<b>Application Ref:</b>	3/2025/0887			 Ribble Valley Borough Council <a href="http://www.ribblevalley.gov.uk">www.ribblevalley.gov.uk</a>
<b>Date Inspected:</b>	25/11/25	<b>Site Notice:</b>	N/A	
<b>Officer:</b>	LW			
<b>DELEGATED ITEM FILE REPORT:</b>				<b>REFUSAL</b>

<b>Development Description:</b>	Proposed construction of a detached garage in the front garden.
<b>Site Address/Location:</b>	53 Knowsley Road, Wilpshire, BB1 9PN.

drawing title  
Proposed Plans  
dwg purpose  
scale As indicated  
@ sheet size A1 rev date  
job number V4-GA-002  
drawing number revision

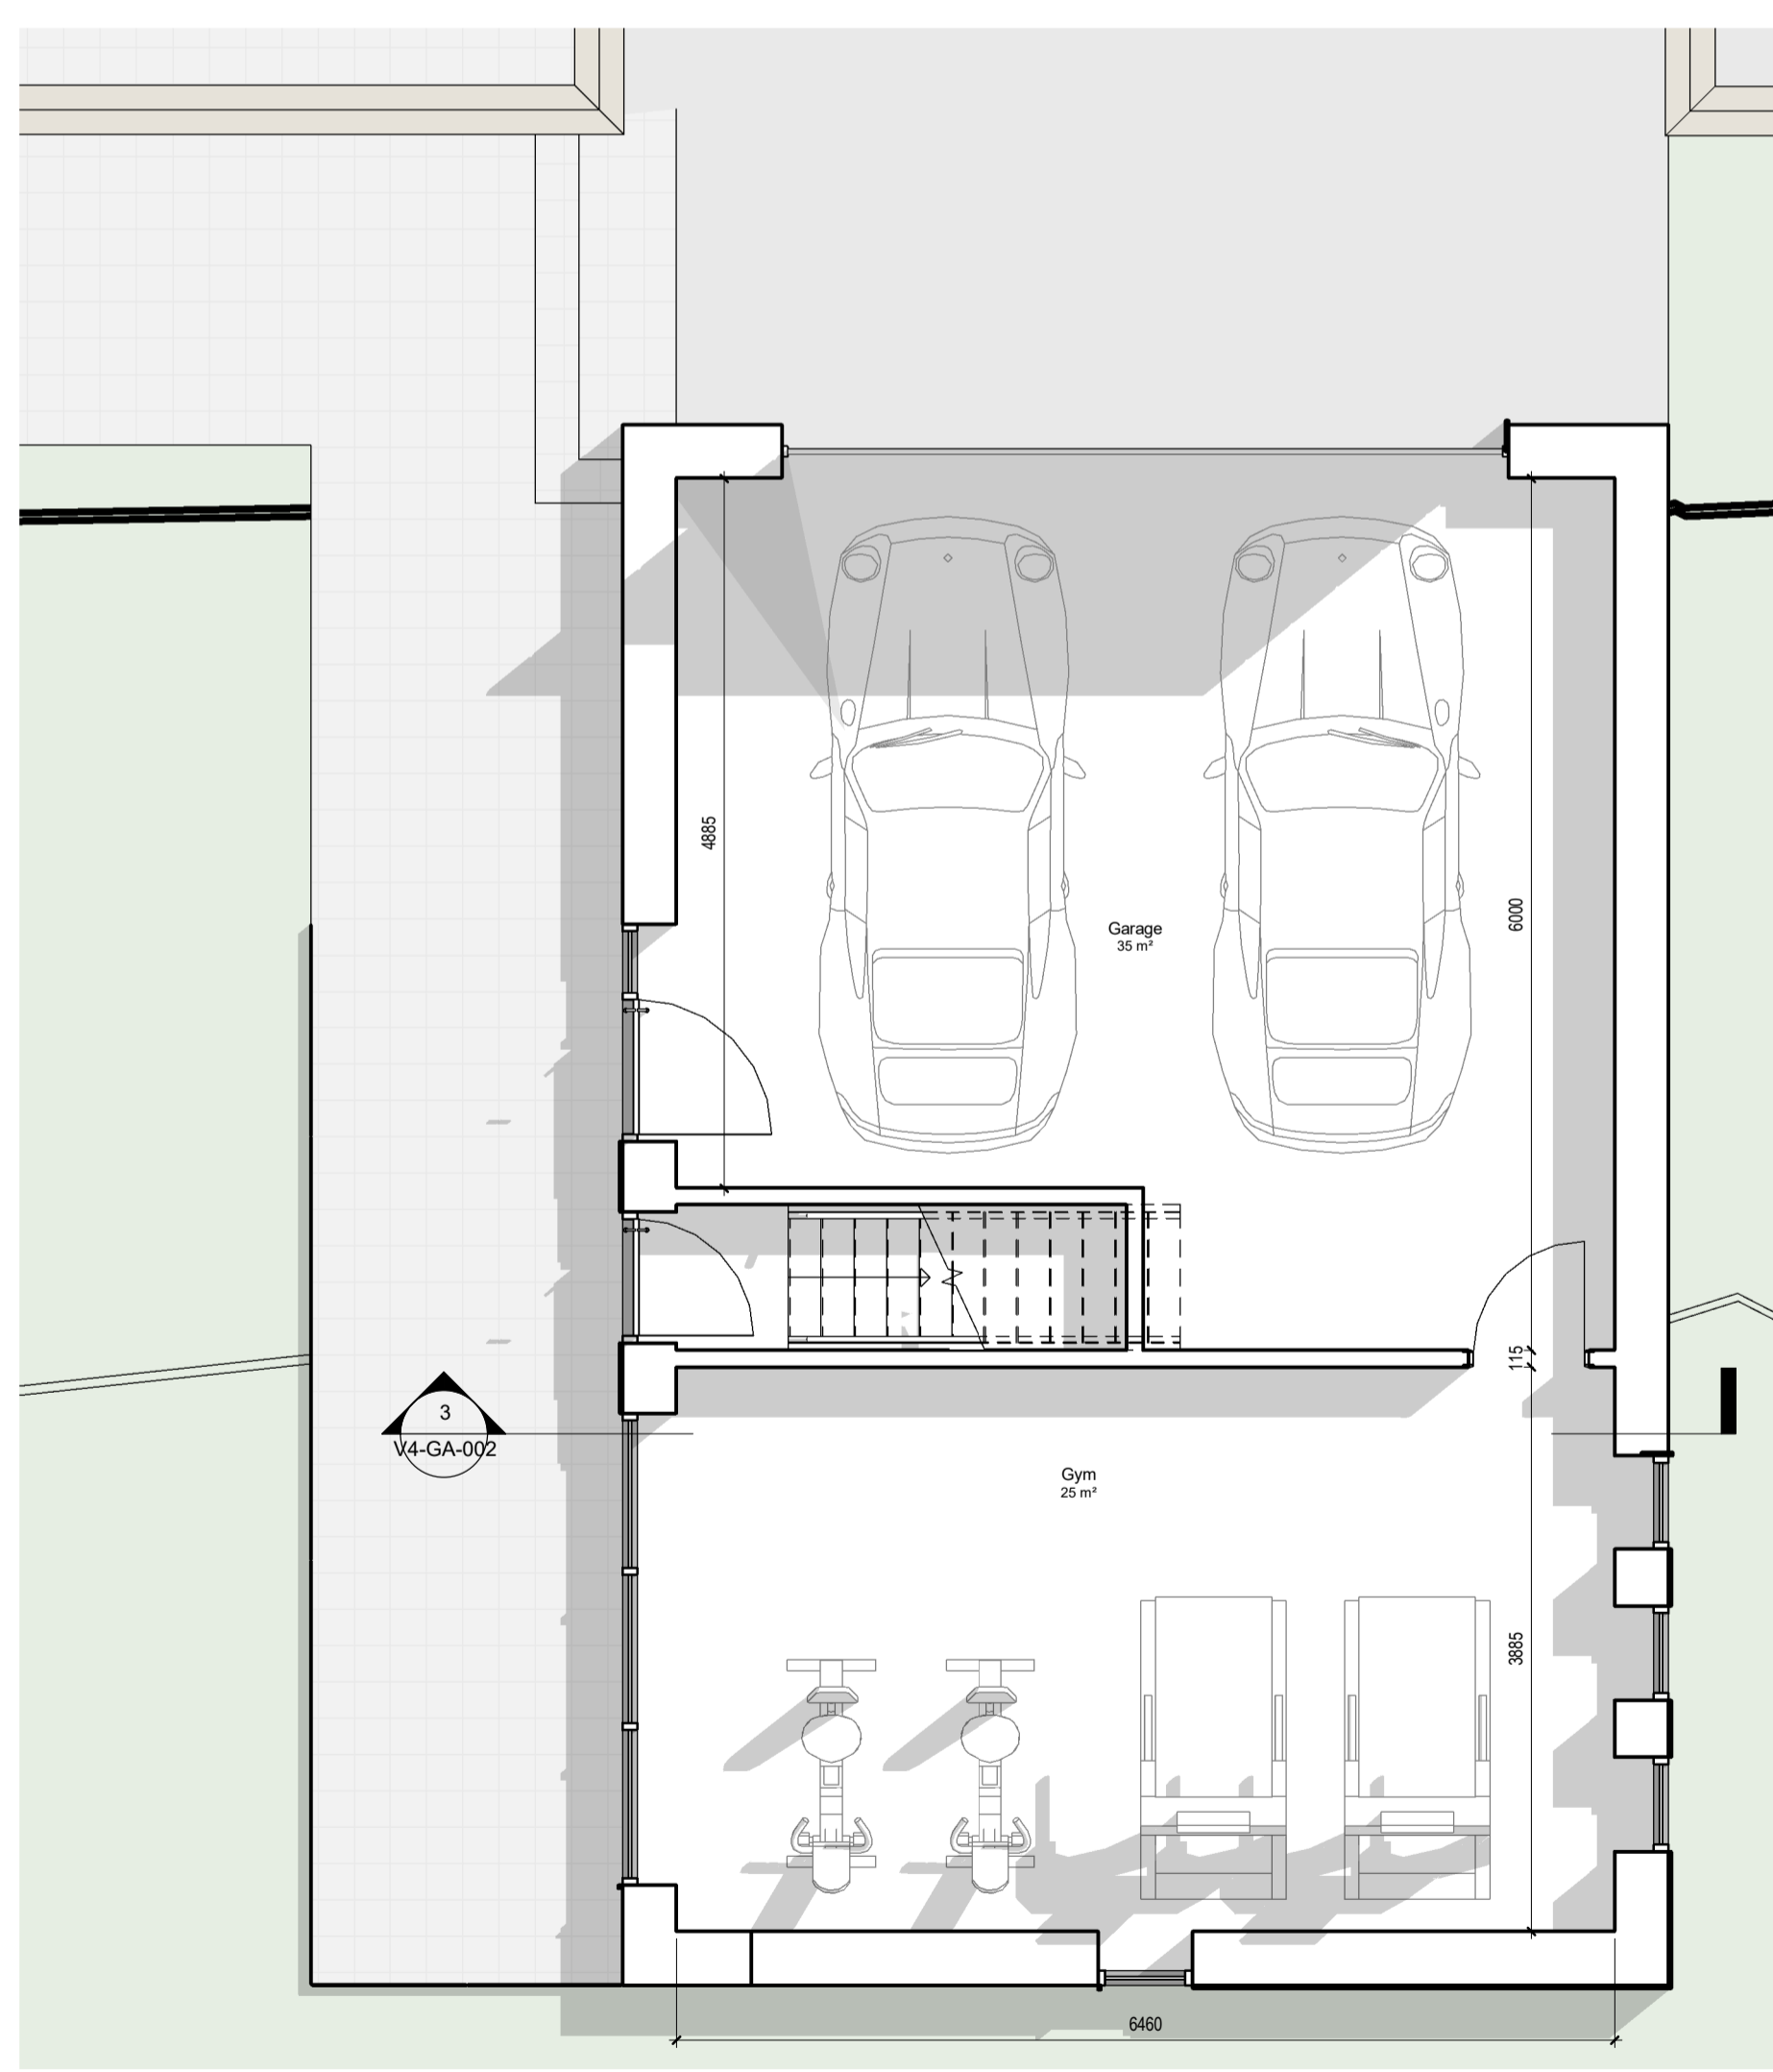
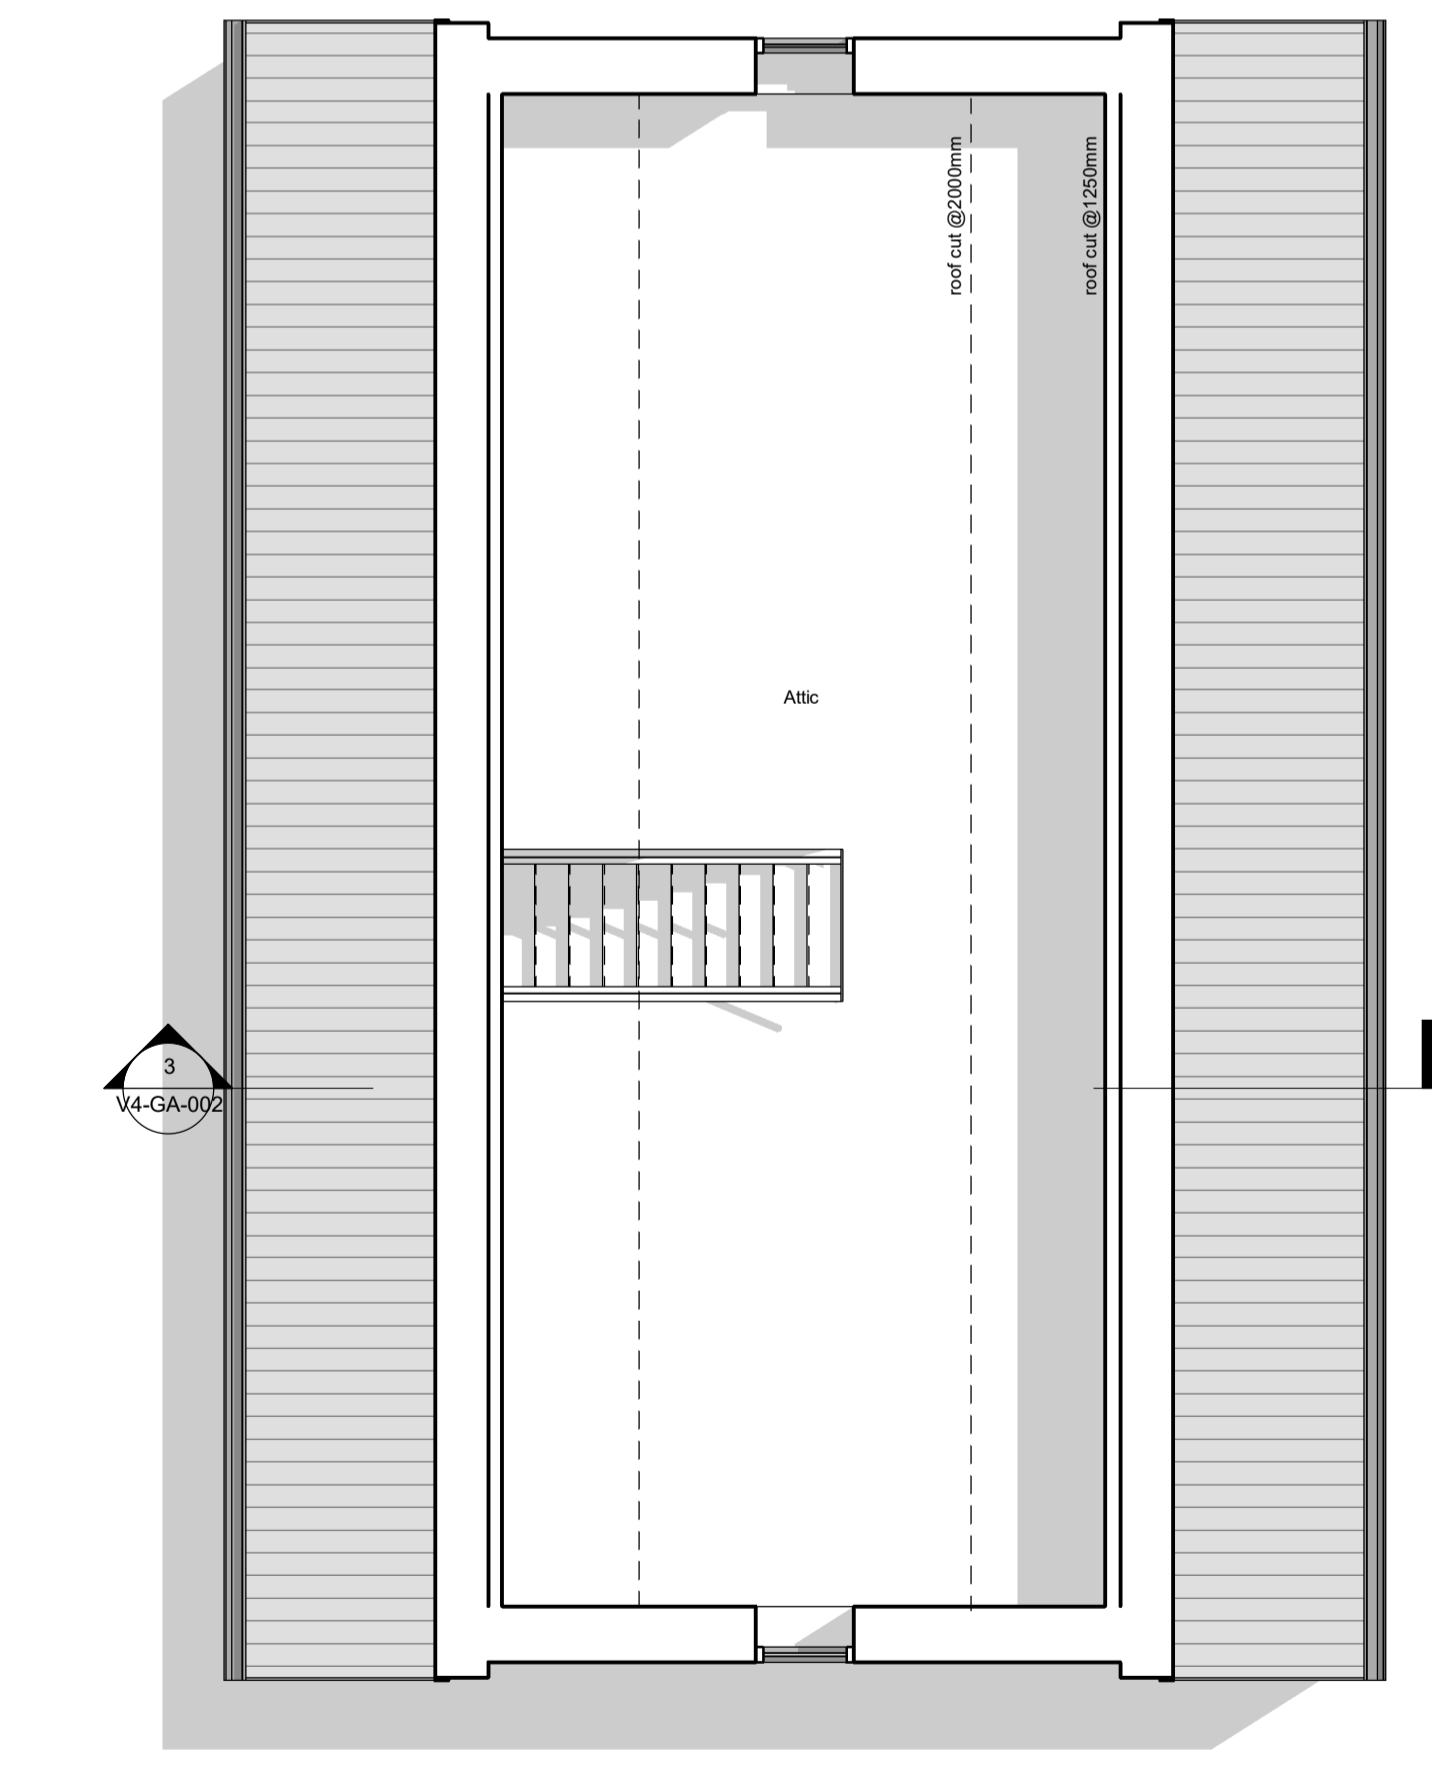
The proposed outbuilding would comprise a substantial footprint measuring 10.7m by 7.2m, resulting in a building of such a size that the proposed development would begin to visually compete with the host dwelling as a large building in its own right, severely reducing its incidental appearance. The harmful effect of this would only be exacerbated by the considerable volume that would be incorporated at roof level in order to accommodate a first-floor attic, as well as the highly prominent location of the building within the south-eastern corner of the site, forward of the principal elevation of the application property and directly adjacent to western boundary of the site. The development would therefore have a clear visual impact upon the street scene, with the size and scale of the building being such that it would adversely affect the proposal site's spacious qualities.

Moreover, the submitted plans show the building to accommodate a double garage at ground floor. However, upon review of the internal dimensions of the garage, one of the proposed parking spaces would fail to meet the recommended minimum internal dimensions for a vehicular parking space, measuring just 4.9m in depth compared to the recommended 6m due to the location of the internal staircase. As such, the proposed double garage would likely only accommodate one vehicle. With this in mind, the size of the building is also considered to be excessive in relation to its proposed use.
